STATE OF NORTH CAROLINA
DEPARTMENT OF TRANSPORTATION

Addendum No. 2

RE: Contract ID C203146

SR-1304 Extension (Roberta Road) Grade Separation Over Norfolk Southern/NCRR
Railroad From SR-1161 To NC-49 In Harrisburg

PROJECT REFERENCE NO. P-5208D SHEET NO. RR-6  
RW SHEET NO.  
RAILROAD DESIGN ENGINEER  
HYDRAULICS ENGINEER

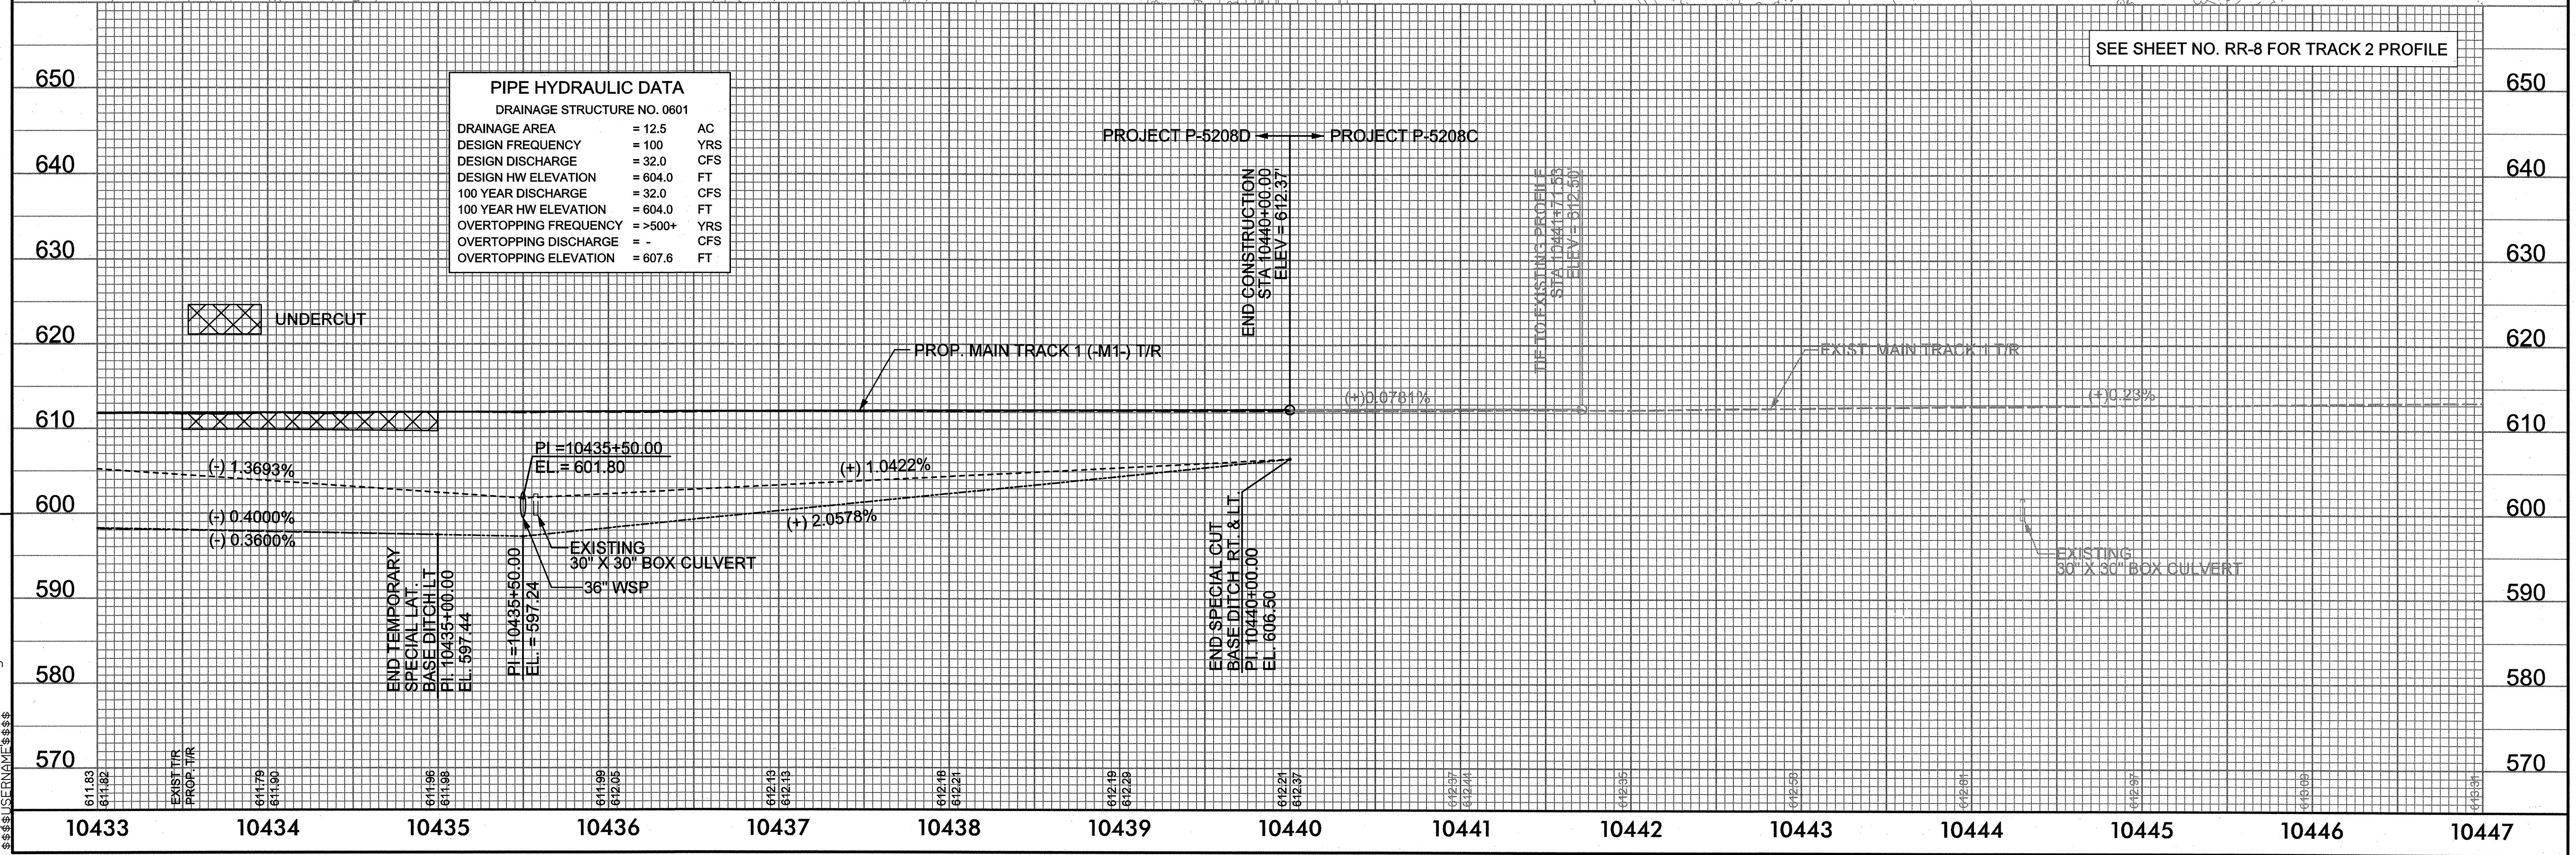
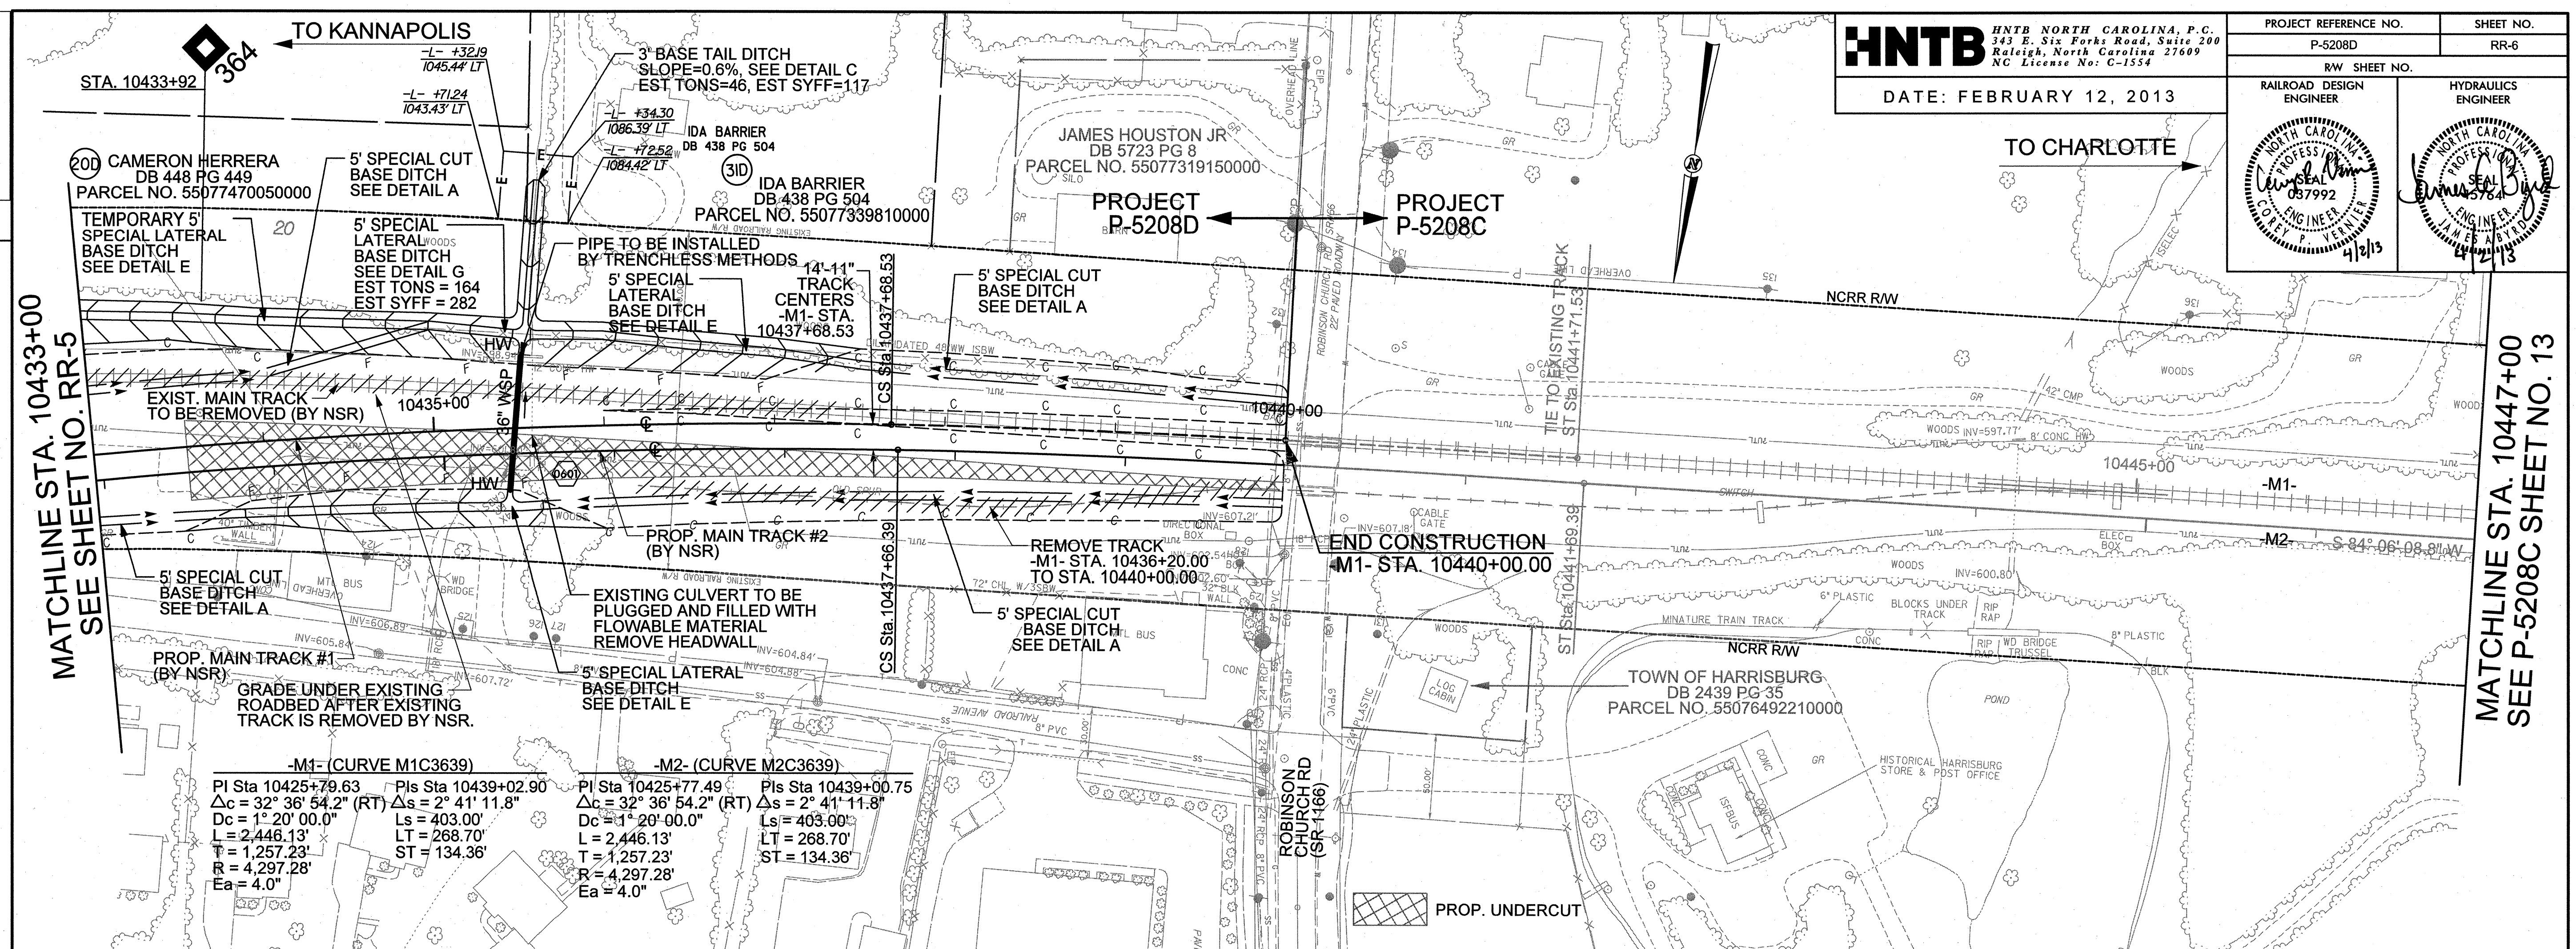
Sheet Nos. RR-2E, RR-6, EC-13 and EC-16 have been revised to reflect the change of a typical ditch to a special ditch between -M1- Sta. 10438+00 and -M1- Sta. 10440+00. Please void Sheet Nos. RR-2E, RR-6, EC-13 and EC-16 in your plans and staple the revised Sheet Nos. RR-2E, RR-6, EC-13 and EC-16 thereto.
